Table 1. Response to RTS Fairfield City Council	
Matter Raised	Comment
A. PLANNING	
<p>The subject site is zoned RU4 Primary Production Small Lots. The proponent has not adequately demonstrated how the development is sympathetic to the rural environment, and how the development is of minimal risk from natural and man-made hazards.</p>	<p>The consolidation of internal learning areas and other internal facilities within a single, two (2) storey built form enables unbuilt-upon area and landscaping to be maximised over the site. Through the provision of vast open spaces and extensive landscaping, the site responds to its rural surrounds and maintains a 'green' and vegetated character.</p> <p>By contrast, the provision of multiple, detached buildings dispersed across the site in an arrangement more typical of older schools which have needed to provide additional facilities over many years to accommodate growth that was not initially planned for, would deplete the available open space and reduce landscaping. Such an approach to the design of the school would contribute to a site characterised by buildings rather than a green landscape, thereby compromising the rural character of the site

1 East Elevation
Scale: 1:200

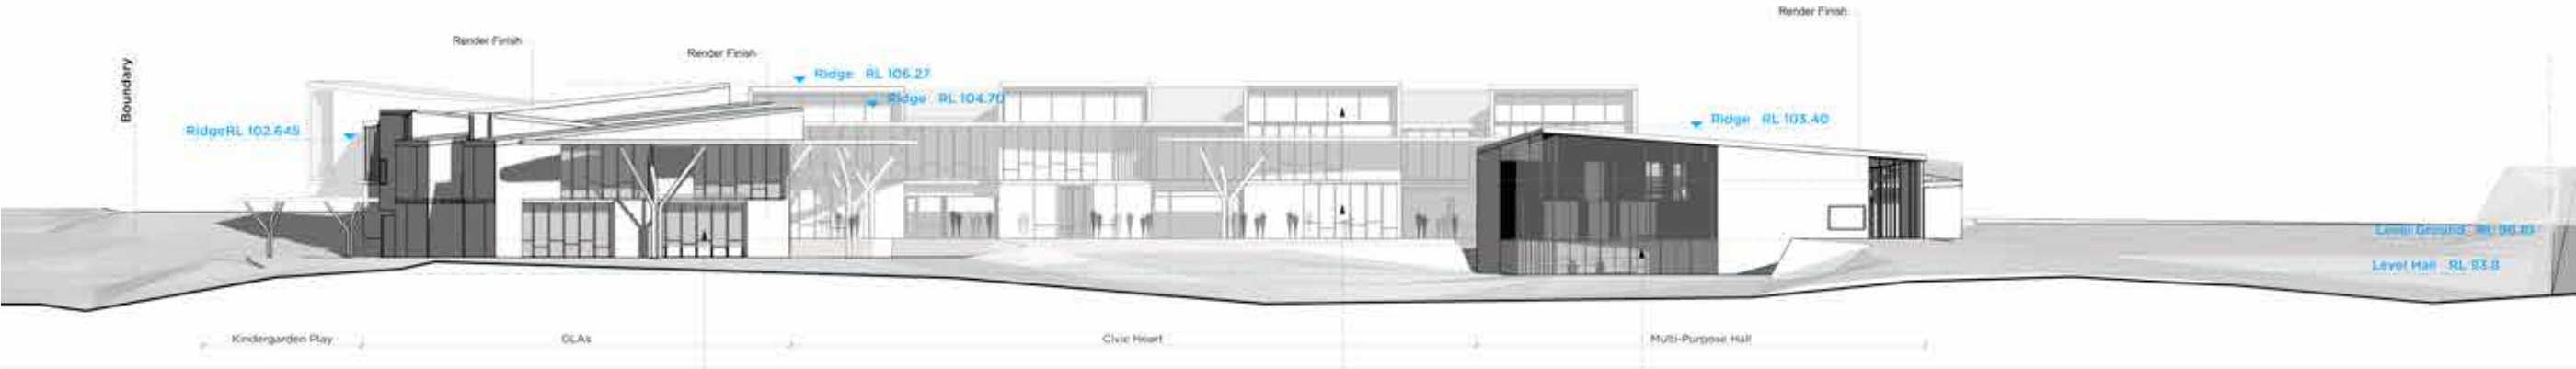
Matter Raised	Comment
	<p>With specific reference to the eastern elevation, the appearance of the length and overall scale of the building wall has been mitigated through the articulation of classroom spaces as separate building volumes, varied façade finishes, modulated roof forms, outdoor learning courtyards and boundary landscaping providing 'green screening'. Also of note, the building wall has been setback a minimum of 20m from the eastern side boundary, which significantly exceeds the 5m side setbacks required pursuant to FDCP and offers significant building separation from the adjoining property. Extracts showing the eastern elevation are provided at Figure 1-2 below.</p> <p>Therefore the design of the eastern elevation and eastern boundary setbacks are <i>not</i> considered to be in any way 'inappropriate'.</p> <p>Similarly, the proposal would <i>not</i> be inconsistent with the objectives of the RU4 zone. Council have specifically queried the proposal's consistency with the following zone objective:</p> <p><i>To ensure that development is sympathetic to the rural environment and minimises risks from natural and man-made hazards.</i></p> <p>As described in the above paragraphs, the development is <i>sympathetic to the rural environment</i> on the following basis:</p> <ul style="list-style-type: none"> ▪ The design integrates with the rural environment through maximising open space, unbuilt-upon area and landscaping over the site. ▪ The appearance of the bulk and scale of the built form has been managed through façade articulation, massing of different building envelopes, treatment of level changes, modulated roof forms, setbacks and landscaping. ▪ Vegetation planting adjacent to the site boundaries will soften views toward the site, riparian planting will enhance the environmental quality of the corridor in the site's west, and more than half of the site will be retained as open space.

Matter Raised	Comment
	<ul style="list-style-type: none"> Canopy trees proposed to be planted will extend above the height of the roofline, thereby assisting the scale of the development to integrate with its landscape. The amenity of surrounding rural properties has been safeguarded through generous boundary setbacks, extensive landscaping and planting of canopy trees. <p>Also consistent with the zone objective, the development has been designed to minimise risk from hazards through:</p> <ul style="list-style-type: none"> Compliant Asset Protection Zones (APZs); Siting buildings outside of the flood zone and minimising cut/fill in the flood zone; Remediation of land contamination on Lot 2321; Compliant riparian setbacks and planting within the riparian corridor; Balancing cut and fill and managing level changes. <p>At the same time as minimising risk to students and staff, these measures will protect natural processes, maintain natural landscapes and improve the environmental quality of the site.</p> <p>The proposal therefore achieves the zones objectives and offers an appropriate response to the rural character of the immediately surrounding context.</p>  <p>Figure 1. Eastern Elevation (PMDL, 2018)</p>
